City of Albuquerque Stormwater Construction Site Inspection Report

ESC File No.	J22E050	Project Name:	Albuquerque School of Excellence		
NPDES Id. No.	NMR1002OT	Location:	13201 Lomas Blvd. NE		
5/20/2021	Owner	Contractor			
Operator	Albuquerque School of Excellence	EPPX			
Contact name & title	Eugene Eski	Juan Olivas			
e-mail	teski@harmonyed.org	jolivas@eppx.net			
Contact Phone #	713-900-7173	505-225-4781			
COA Inspector	Thomas Evans	Start/End Time:	12:25 PM/12:30 PM		
Construction Phase:	Stabilization				
Type of Inspection:	Regular	Storm Event	Past Storm Event >0.25"	311/Complaint	Follow Up
Weather at time of inspection?	clear	Temperature:	~ 78		
Estimated date of last storm 0.25" or greater	5/3/2021				
Item Number	Deficiency/ Corrective Action				
1	None.				
2					
3					
4					
5					
2.1	Discharge off site? (Y/N)	no			
4	Self Inspection Reports	Requested	Latest report Date:	4/12/2021

ABO SCHOOL OF EXCELLENCE		DRAWN BY pm
	OVERALL GRADING AND DRAINAGE PLAN		DATE 7-20-2020
	TIERRA WEST, LLC 5571 MIDWAY PARK PL NE ALBUQUERQUE, NEW MEXICO 87109 (505) 858-3100 www.tierrawestllc.com		DRAWING 2019068-GR
	SHEET # GR-1		JOB # 2019068

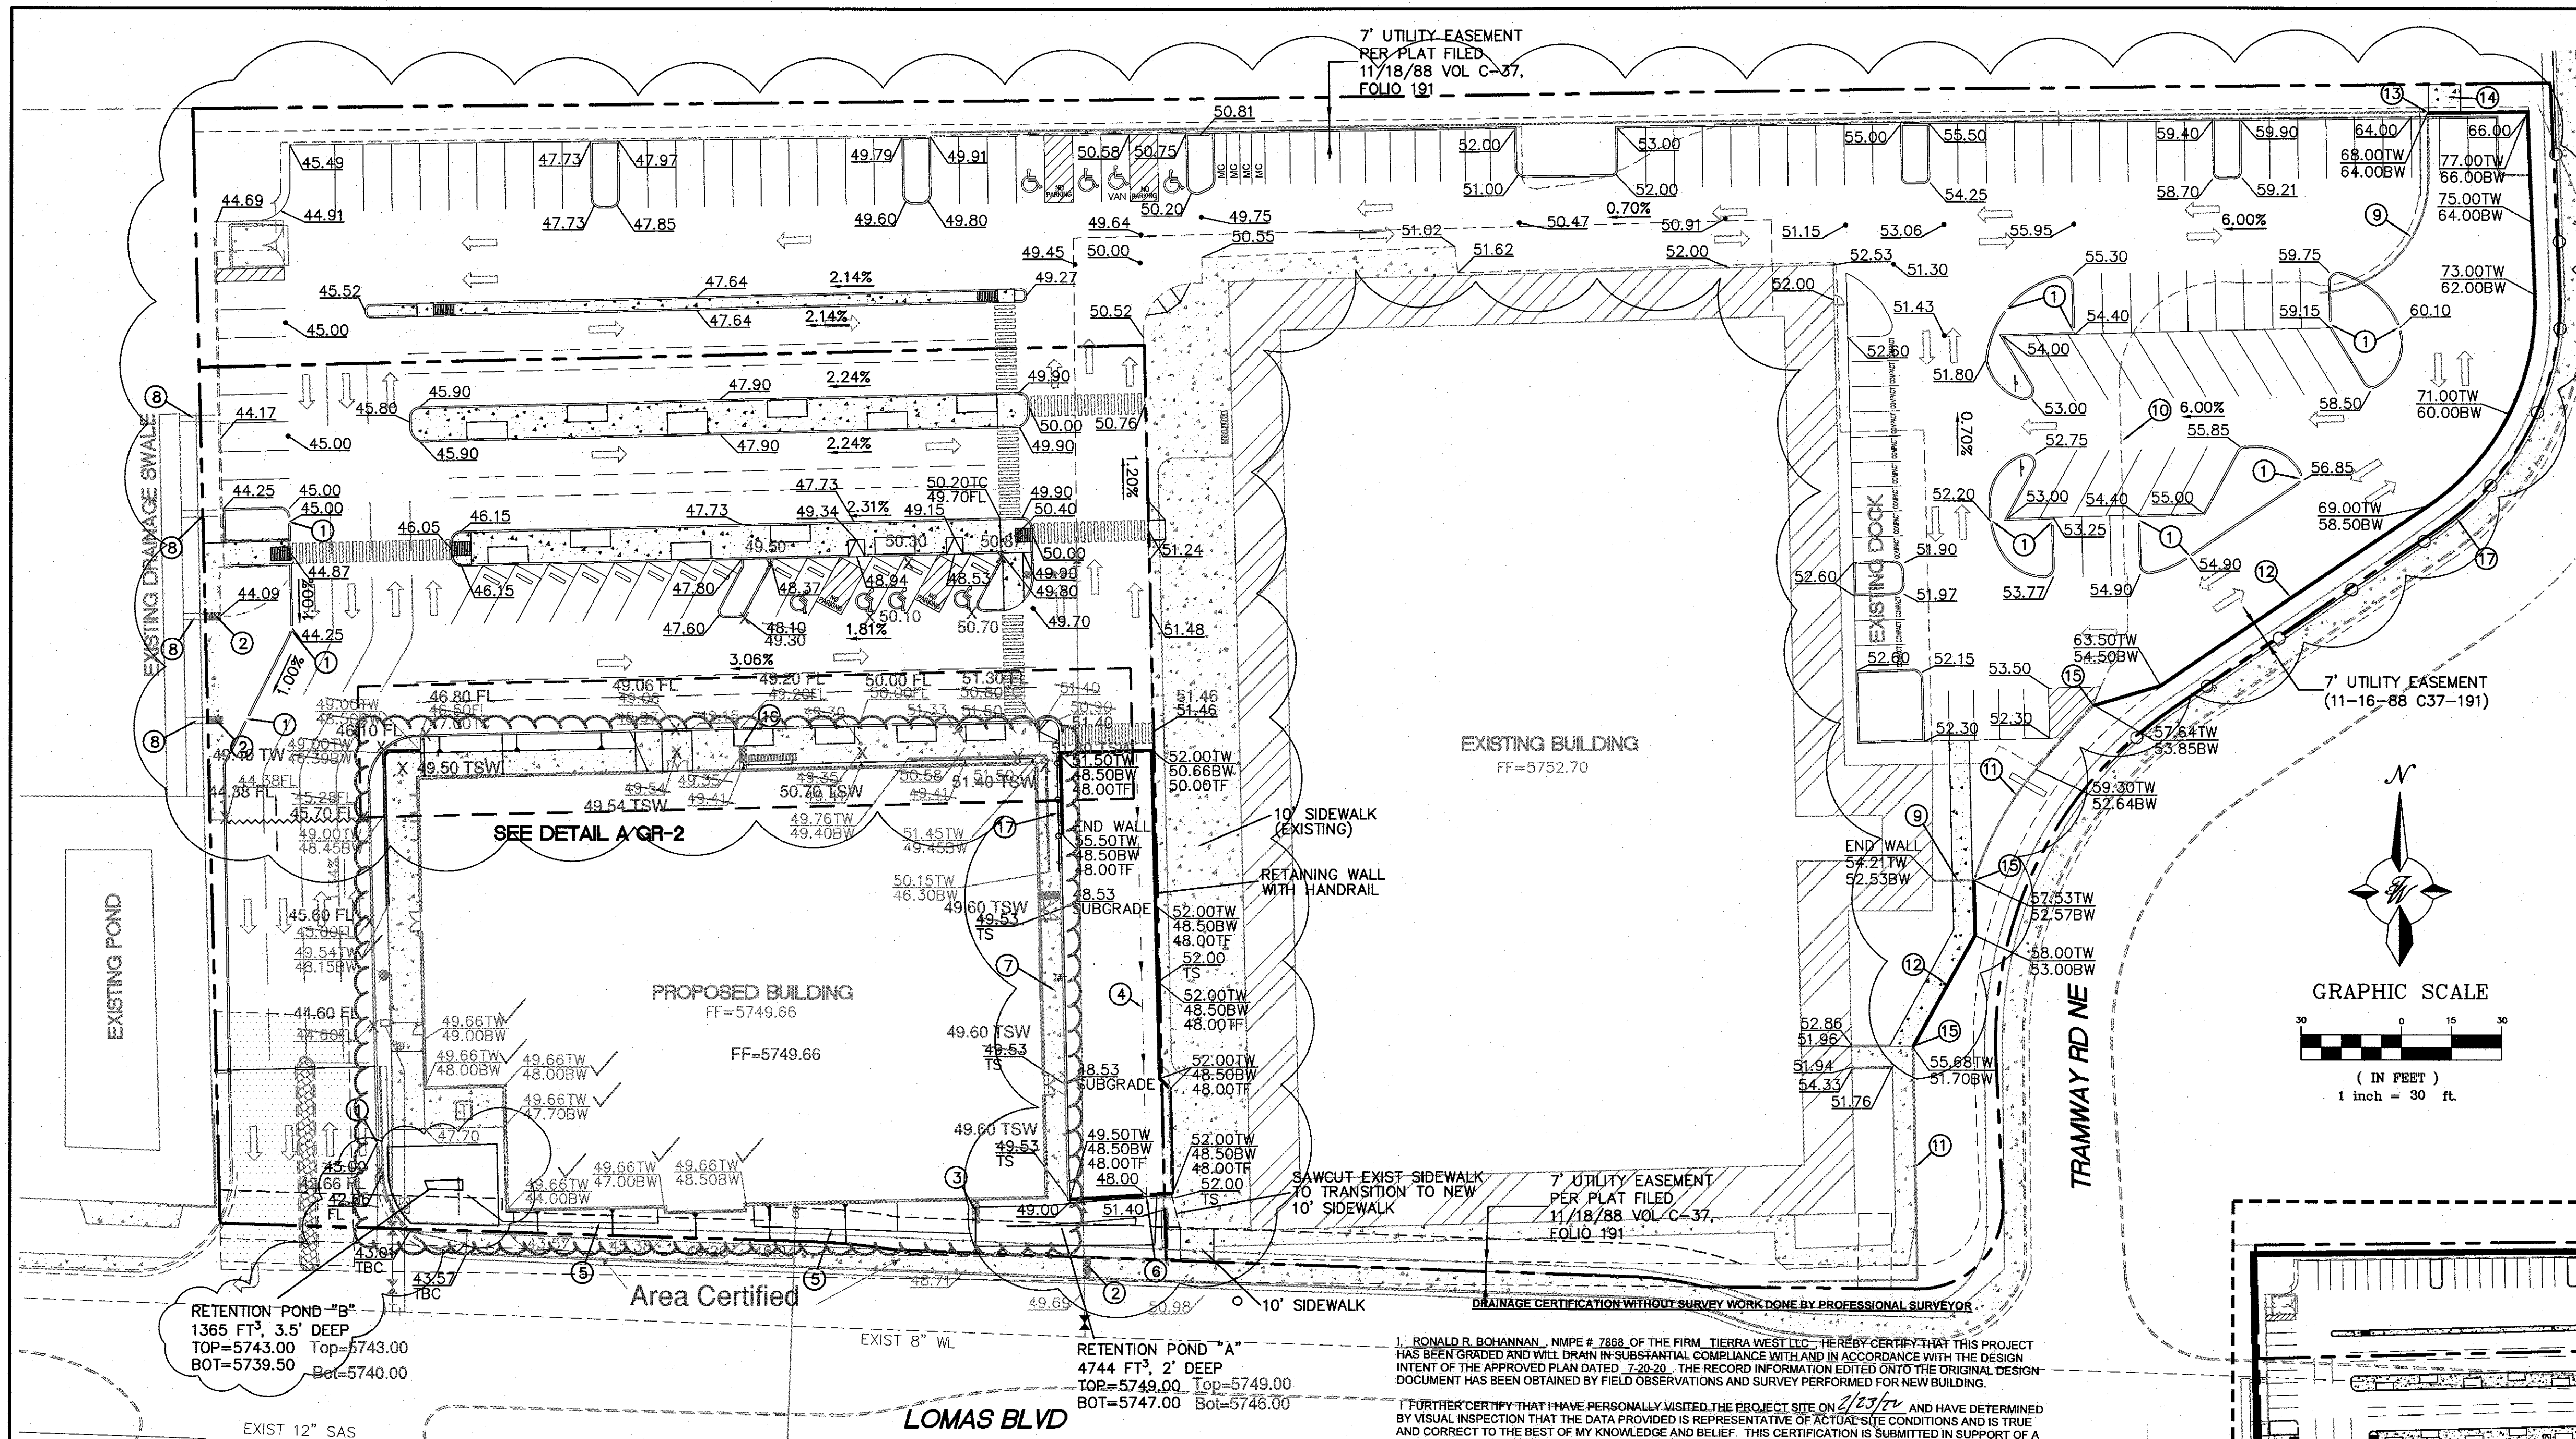
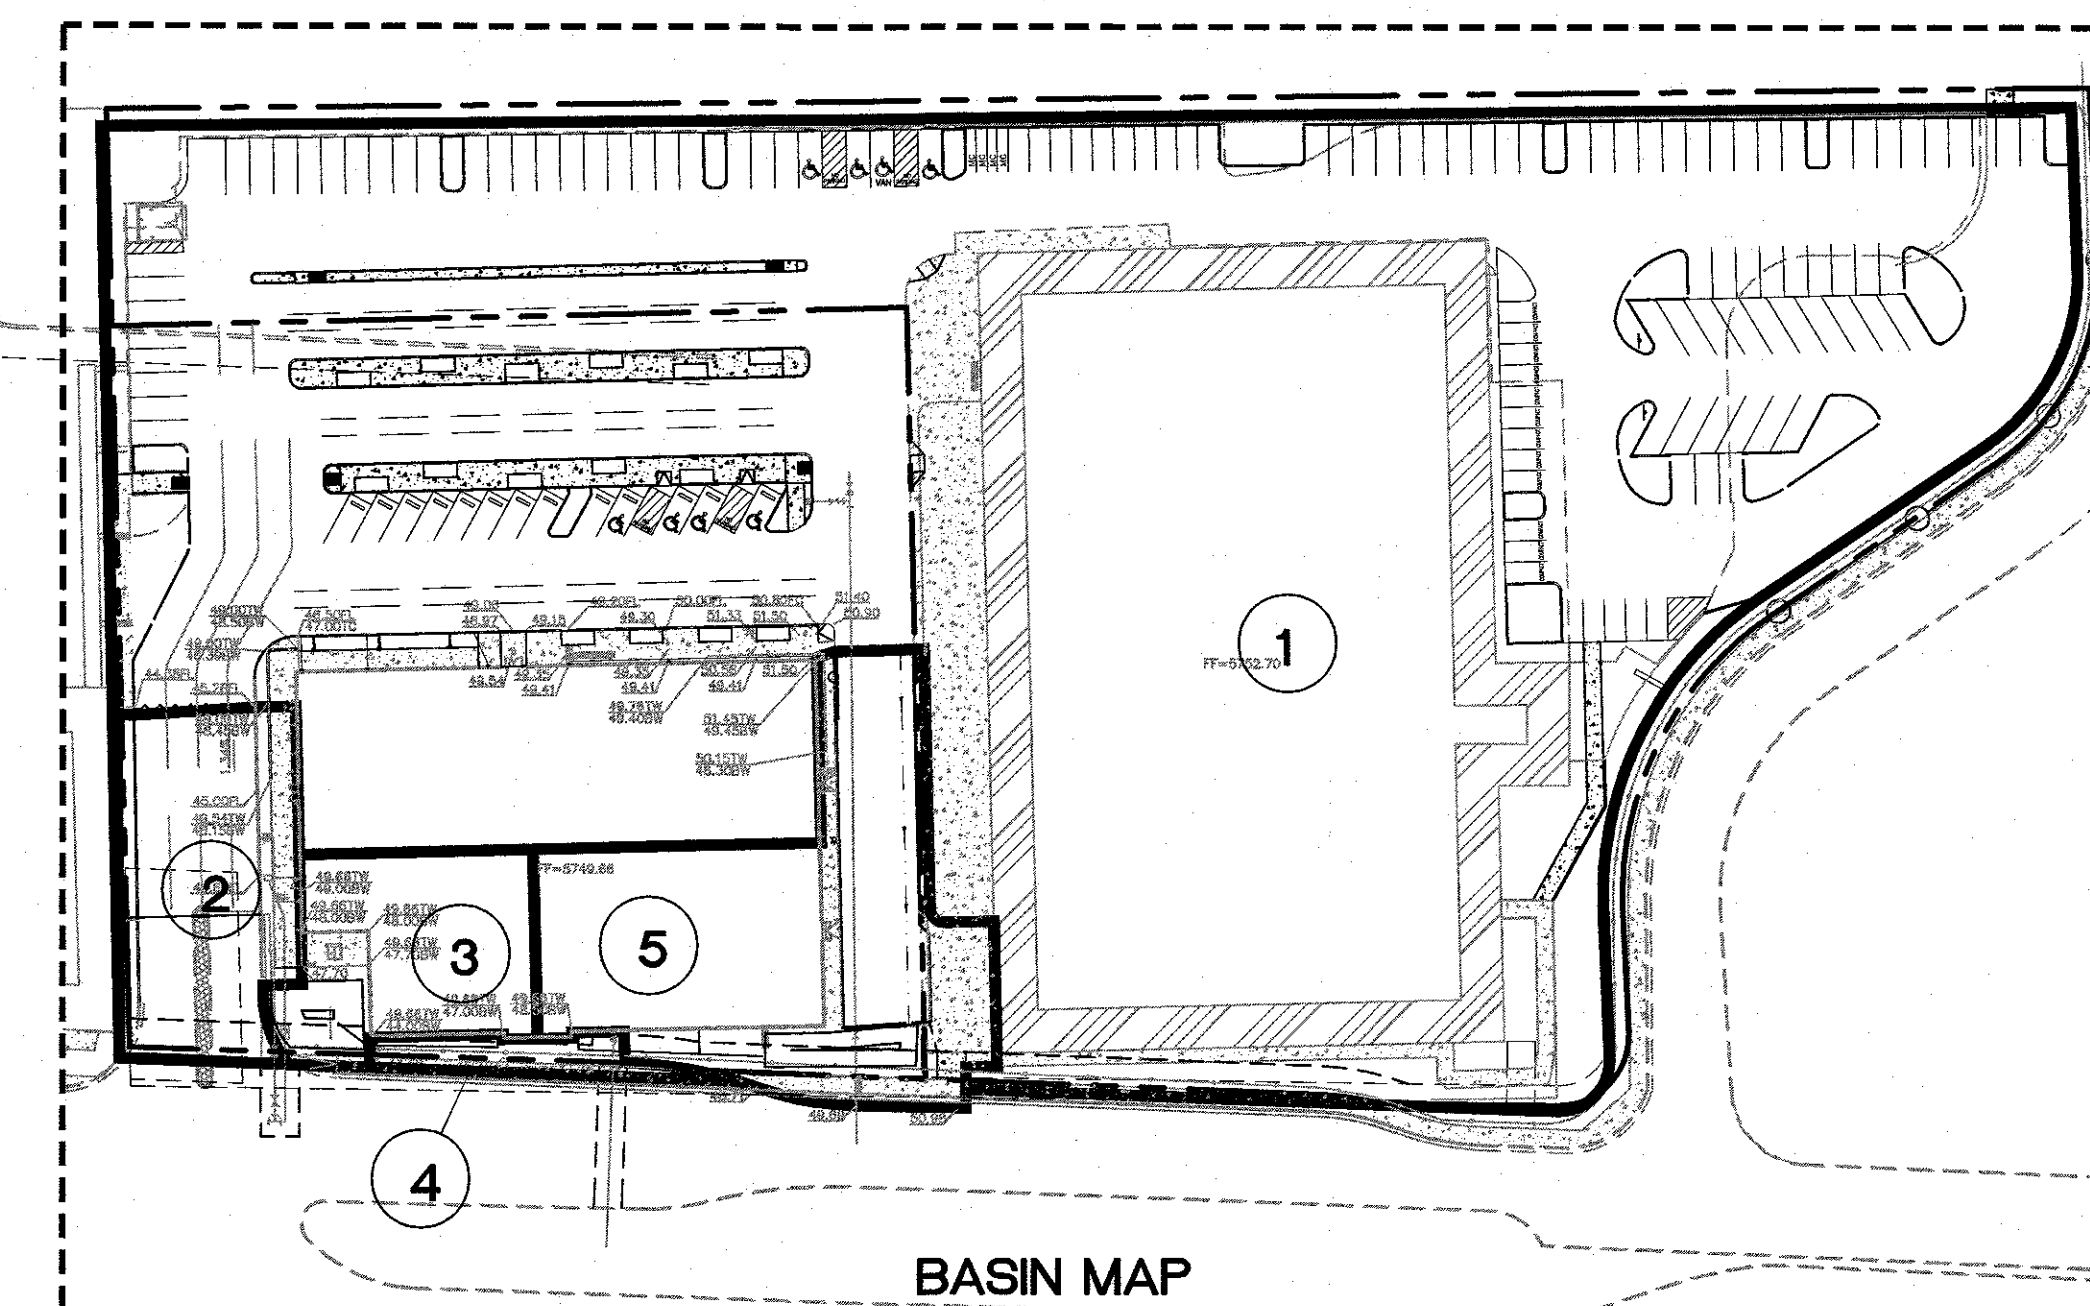
Notes:	Recommend gravel on the slope on the East side of the site for stabillization.
